Your Ref: OWPC23160
Our Ref: FP/110/19/HH
Please ask for:
Amber Willard

23rd May 2019

Single storey front & rear extensions.
65 Wroxham Way Felpham

PROPOSED PLANS
PROPOSED ELEVATIONS
SITE PLAN.

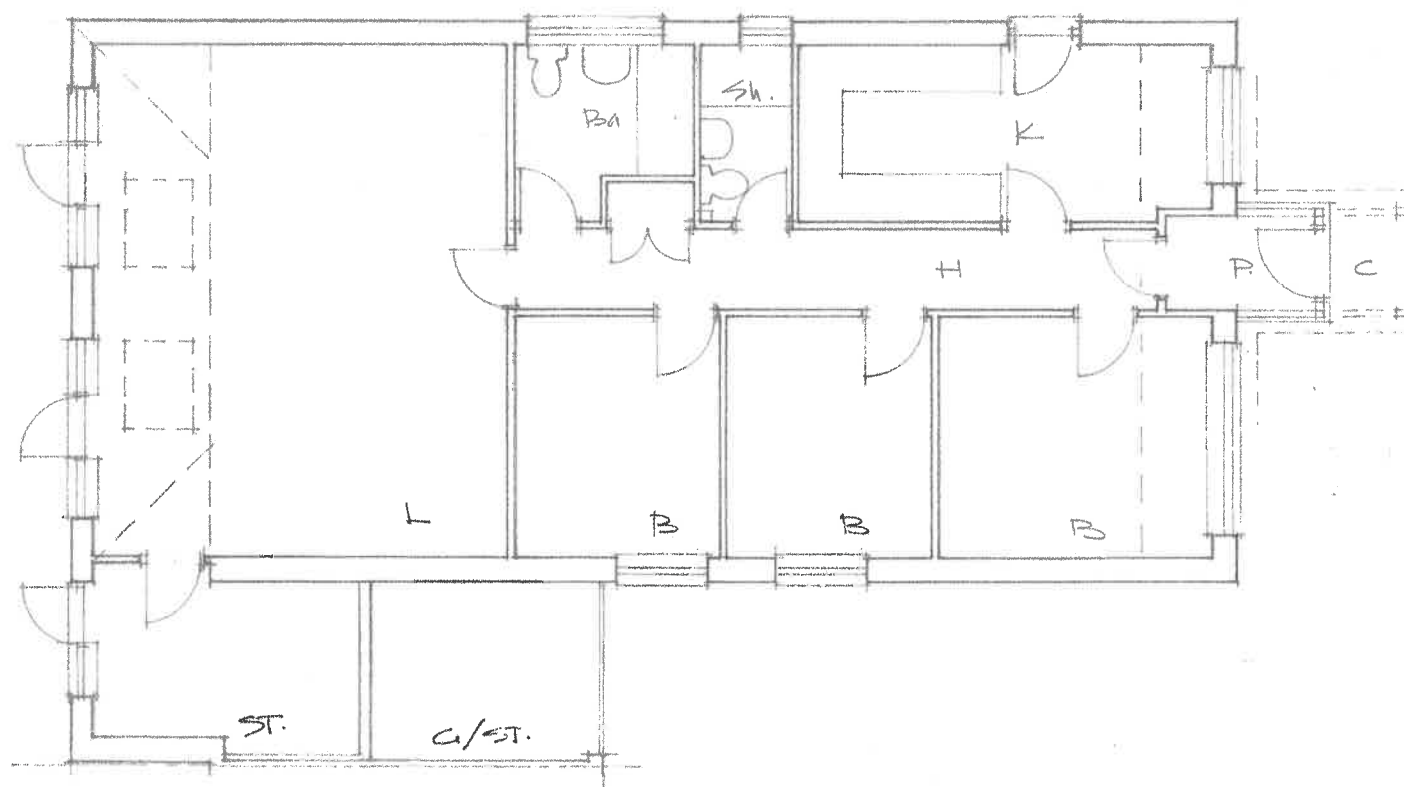
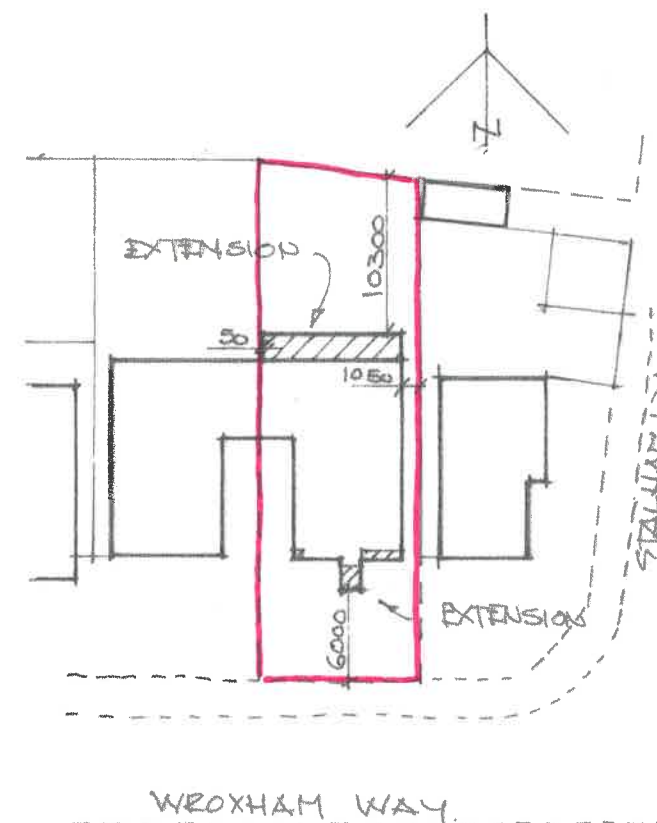
proposal goes beyond the property line of adjoining properties.
